Introduction

These comments relate to a full planning application for development of employment Class E(g) – ‘Commercial, Business and Service Uses that can be carried out in a residential area without detriment to its amenity’.

The northern part of the site is allocated in the Cherwell Local Plan (2015) as part of the Bicester 10 allocation and is intended to form the final phase of the Catalyst Bicester Business Park. There is an extant outline planning consent for the site, which was granted in 2017 reference 16/02586/OUT.

Drawing Title:
Detailed Soft Landscape Proposal (Sheet 1 of 6)

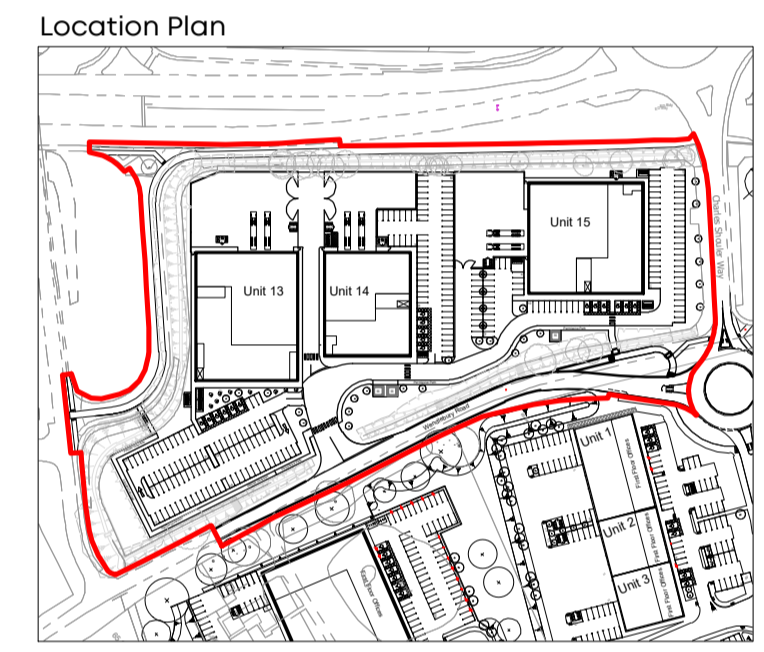
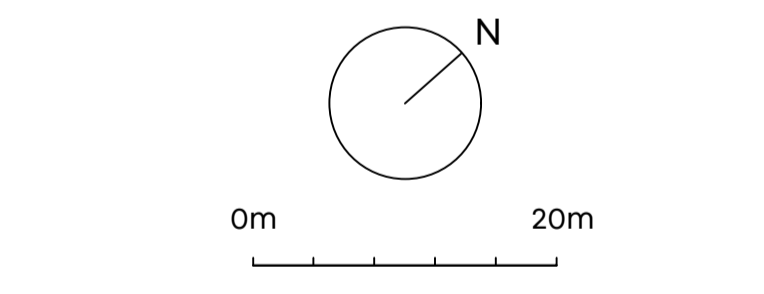
Existing and proposed trees and vegetation are important to provide structure, character, legibility and containment. The landscape proposals indicate existing boundary vegetation would be retained. This aspiration is likely to conflict with the functional requirements of the drainage ditches and widening of the footway alongside the A41. The proposed planting in general does not reflect the scale of the proposed buildings and prominent gateway location.

The landscape proposals should be reviewed and updated with replacement and additional planting where necessary to maintain and enhance the verdant character; screen the rear elevations of Units 13 and 14 from the A41; and ensure planting at the site gateway in particular, will be of an appropriate scale and long-lived.

The proposed car park area adjacent to Wendlebury Way presents a large expanse of parking. This should be broken up with tree planting through the central bays. Trees would provide multi-functional benefits including shade, shelter and soften the appearance of the parking and buildings. It would also contribute to the character and identity of the development in accordance with policy and guidance.

The proposed permissive footpath and diverted footpath would take a circuitous route along the site access and around the car park. The alignment should provide a clear, attractive and direct link between Wendlebury Way and the proposed shared surface track to the south-west. The proposed alignment would not meet the requirements of the National Design Guide, which states at M2 that priority must be given to pedestrian and cycle movement. M2 goes on to state that Public Rights of Way must be protected, enhanced and well-linked into the wider network of pedestrian and cycle routes. Routes are required to be safe and direct with visible destinations or clear signposting to encourage people to walk and cycle.

01 REFUSE ENCLOSURE
017 typical plan

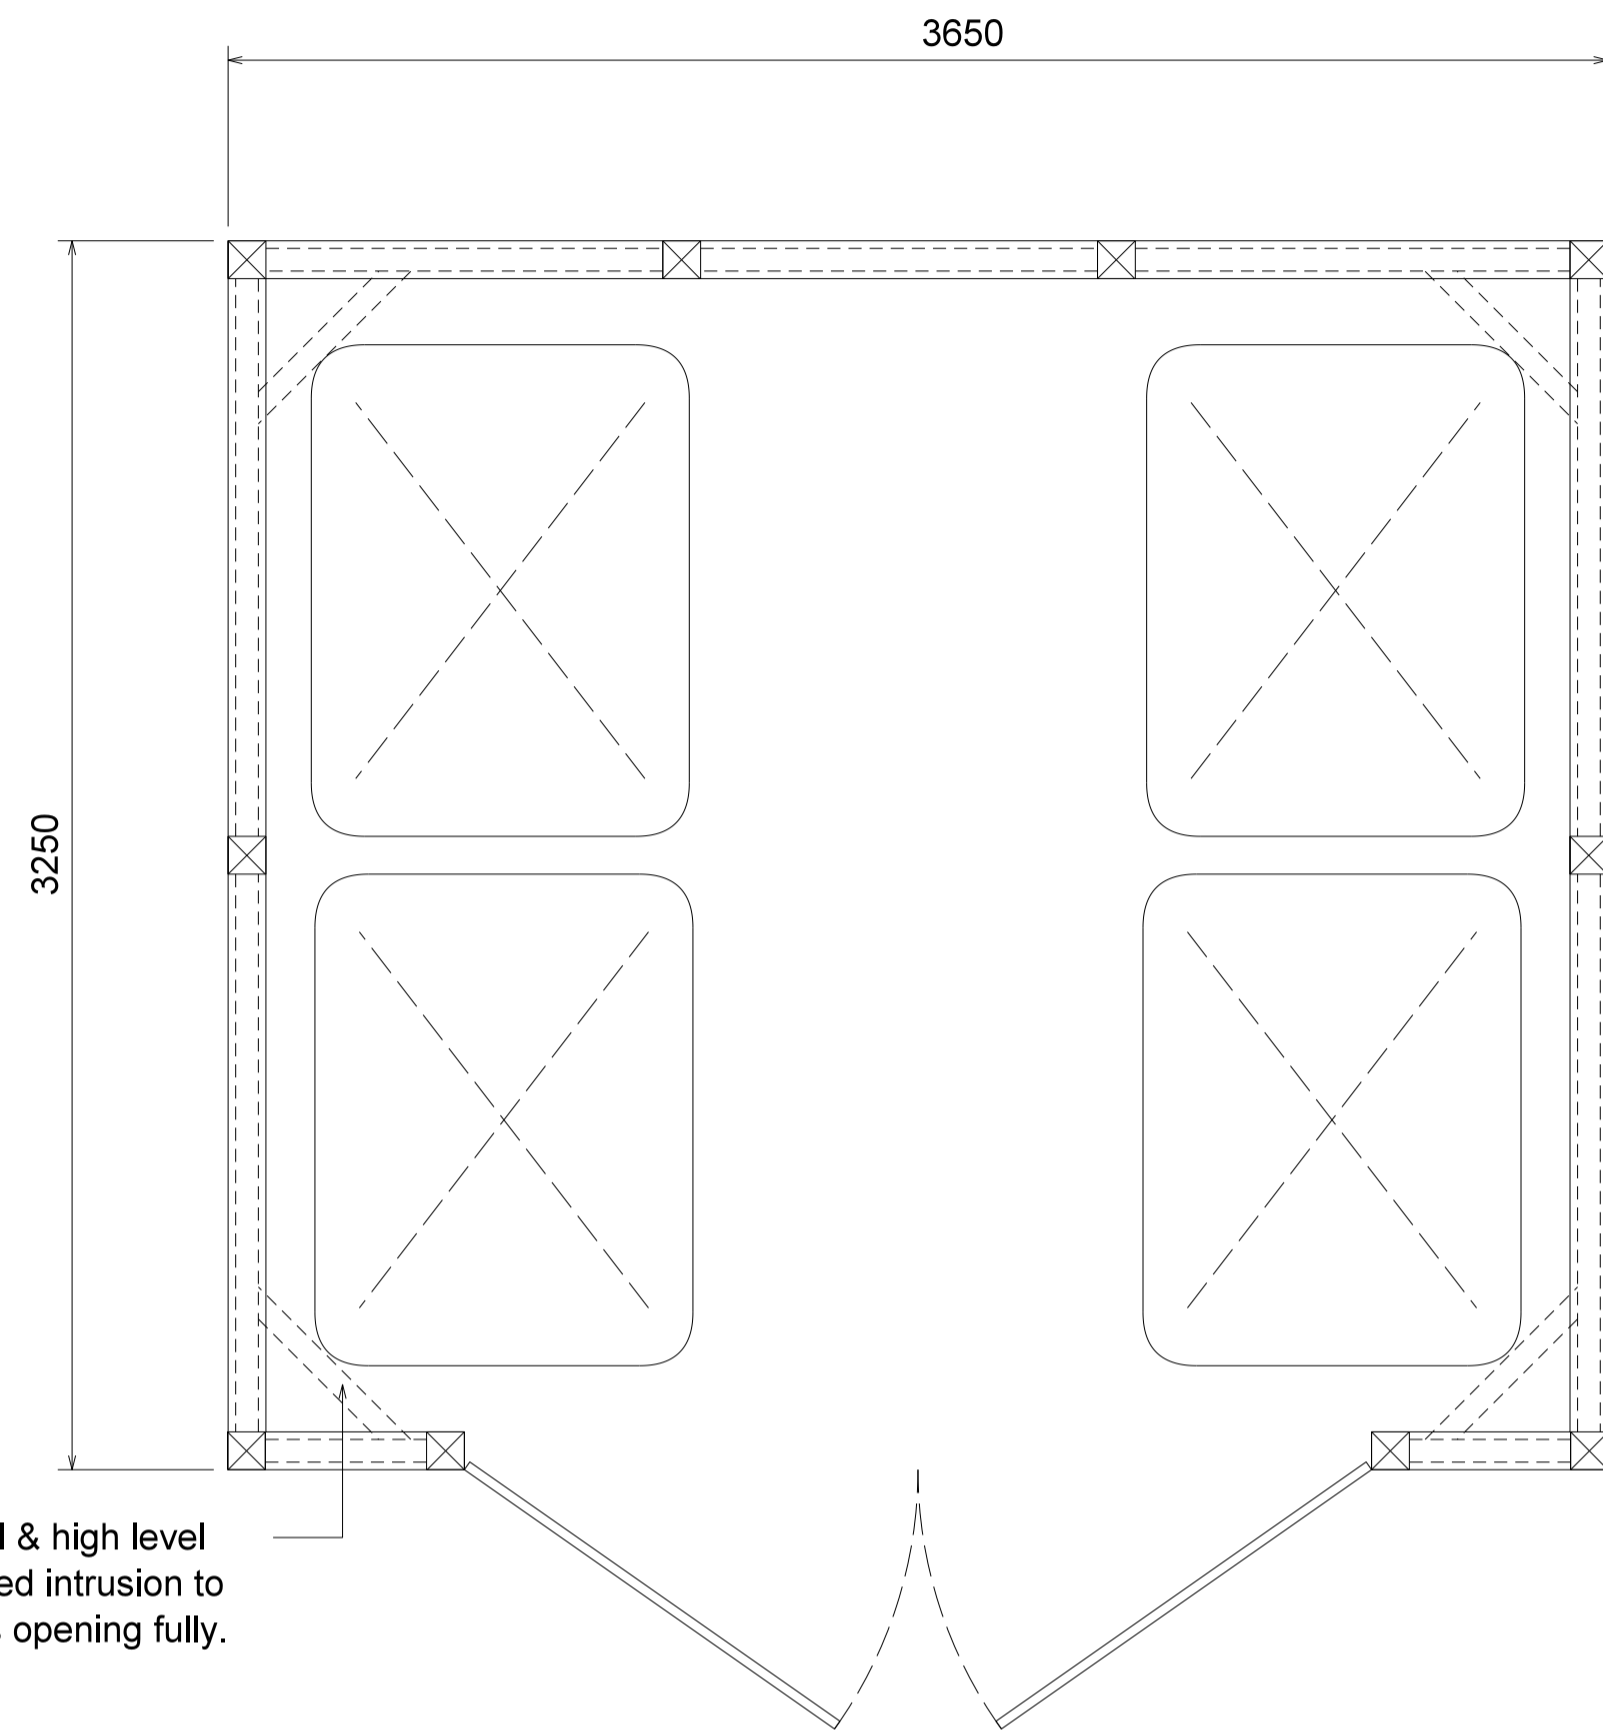
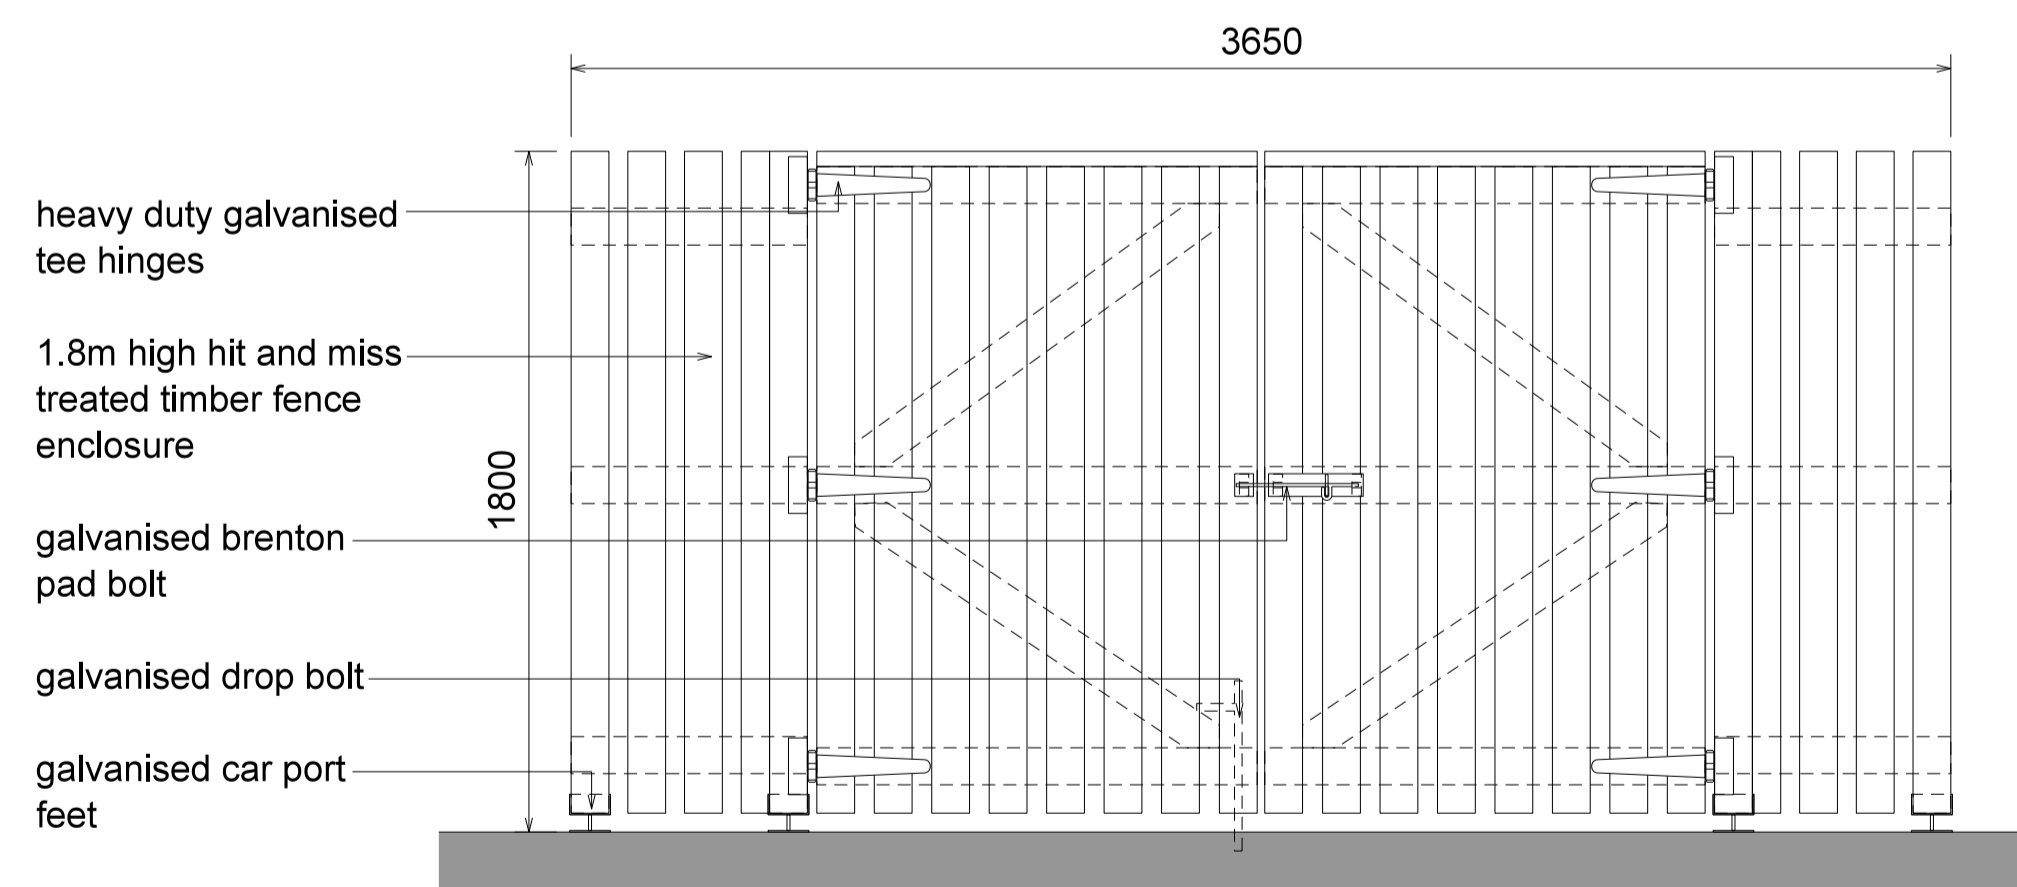
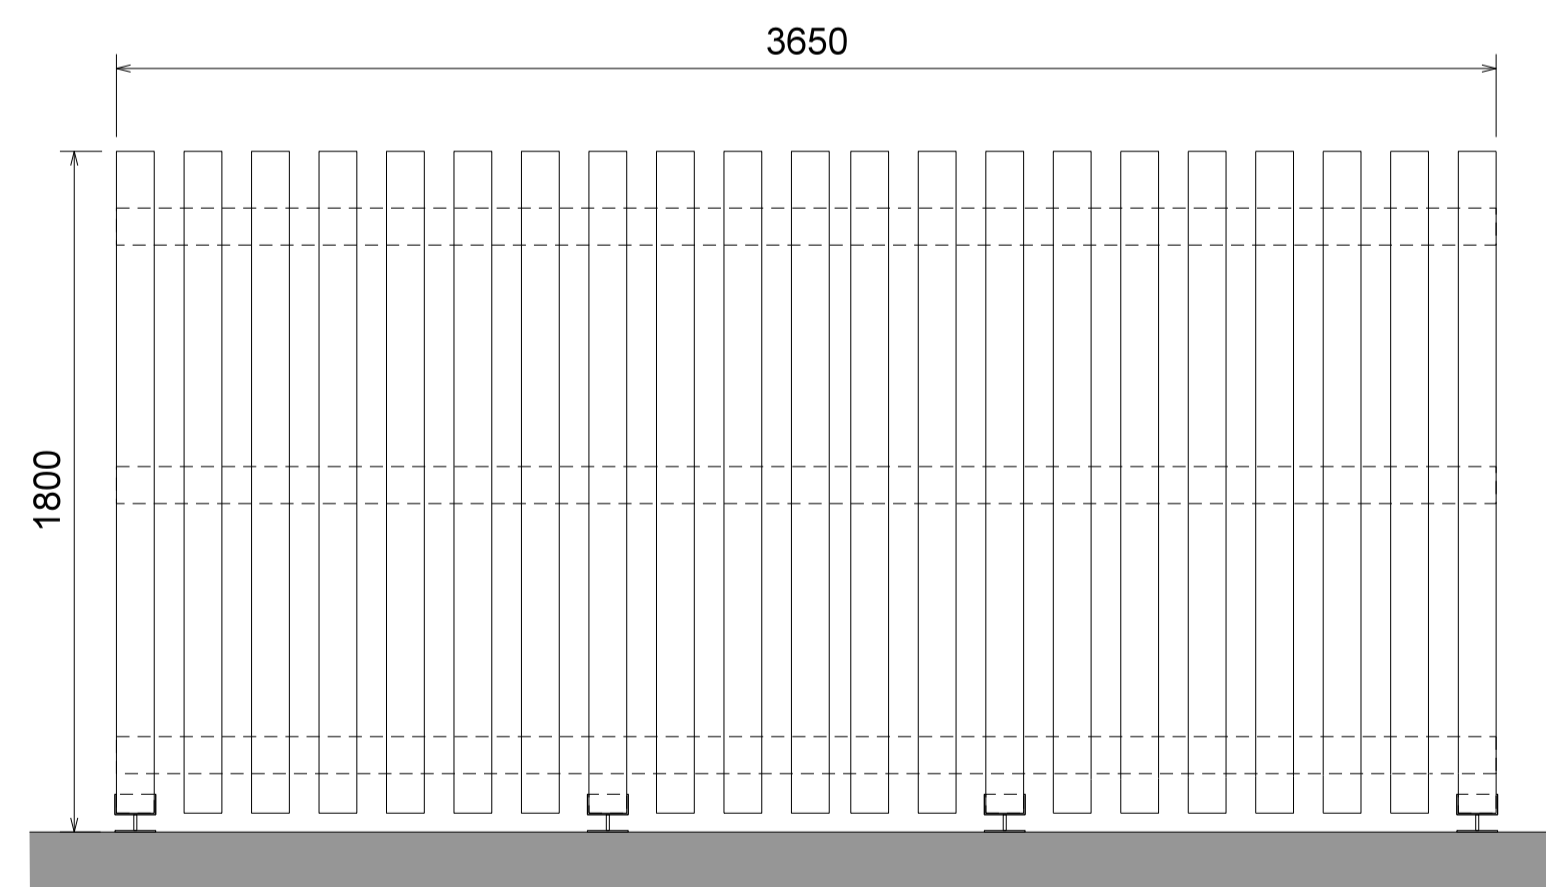
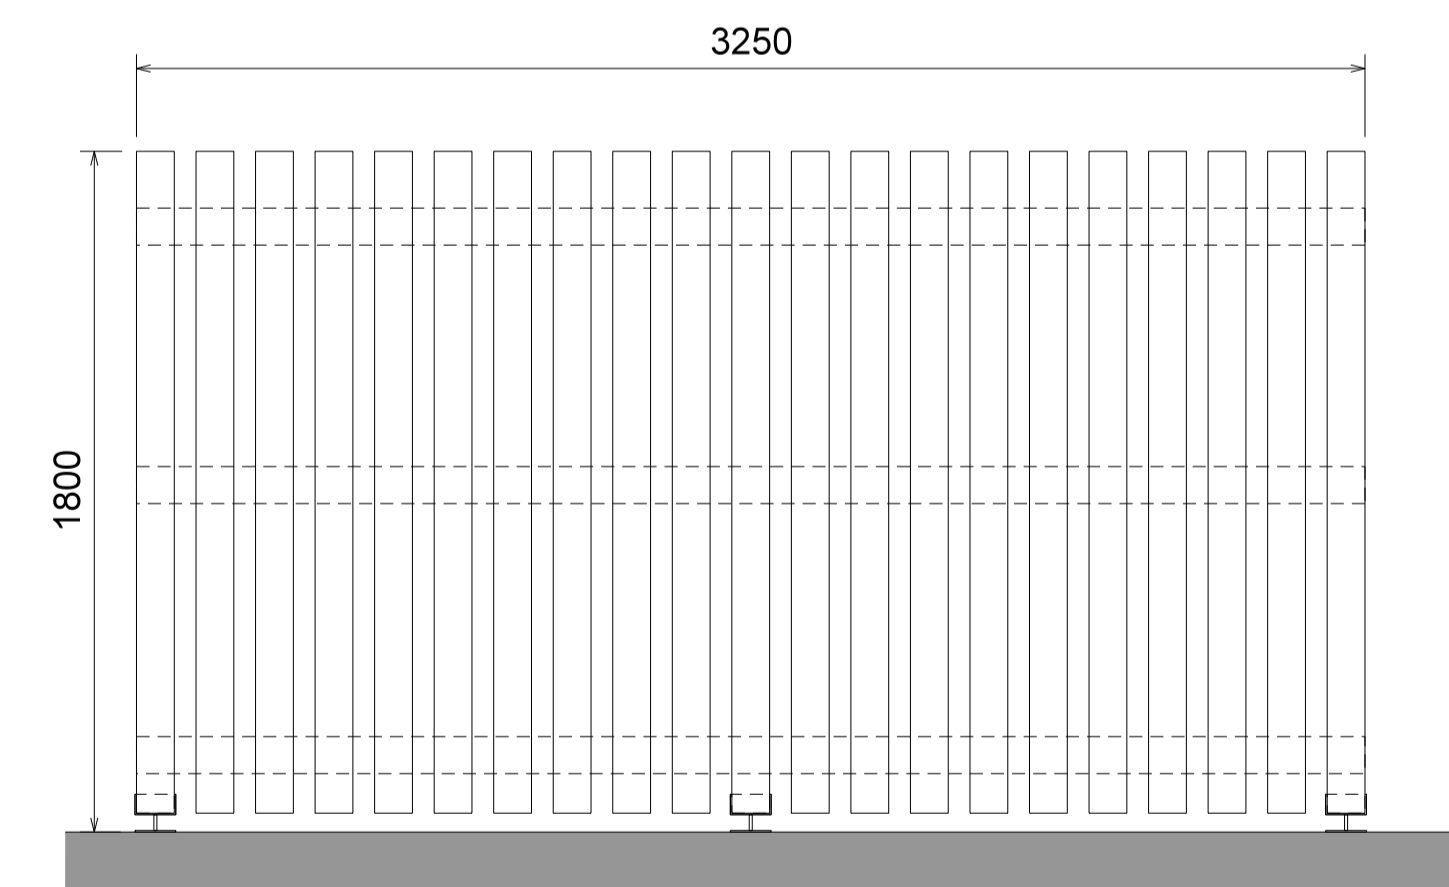
integrated into the public realm landscaping. The proposed Sheffield type stands and canopies are more suited to visitor/short stay cycle parking. Bin stores are also required to be well integrated into the design to minimize visual impact, unsightliness and clutter.
